From: Anita Gardner
Sent: 04 May 2012 10:20
To: Planning.Responses
Subject: FW: AB/36/12/DOC New Heritage Centre Mill Road, Arundel - protection of the scheduled monument (Blackfriars)

From: Mark.Taylor@westsussex.gov.uk [mailto:Mark.Taylor@westsussex.gov.uk]
Sent: 03 May 2012 15:08
To: Anita Gardner
Subject: AB/36/12/DOC New Heritage Centre Mill Road, Arundel - protection of the scheduled monument (Blackfriars)

Arundel Museum – Site set up plan

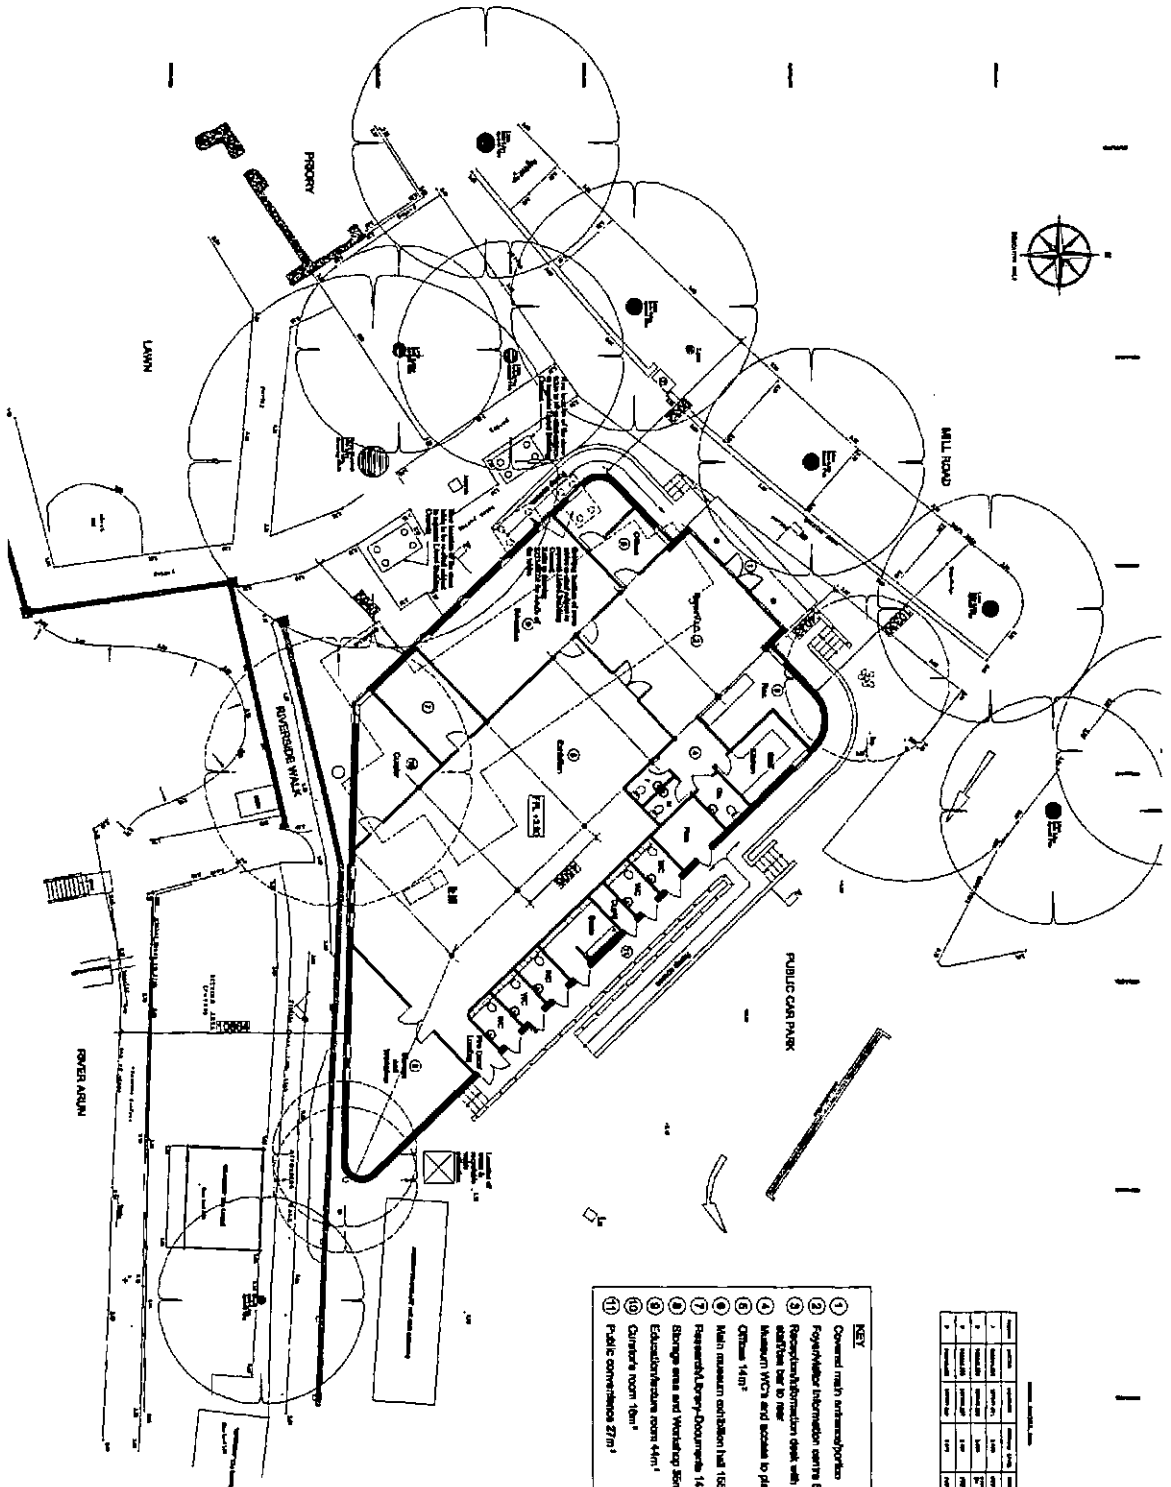
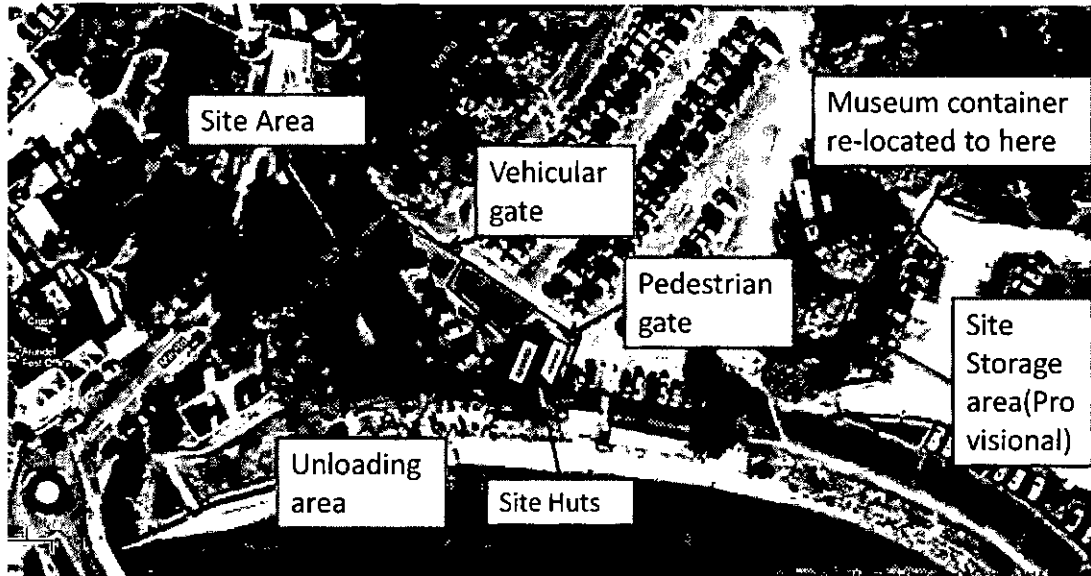
Dear Anita, further to our telephone conversation earlier today I can confirm that I am happy with the method proposed under condition 9 for the protection of the scheduled ancient monument, namely that all access to the construction site and compound will be from the Mill Road car park entrance on the eastern side of the 'footprint' of the new building. Given adequate Heras fencing and the presence of the TPO mature chestnut tree there should be no foreseeable issues. Yours sincerely, Mark Taylor
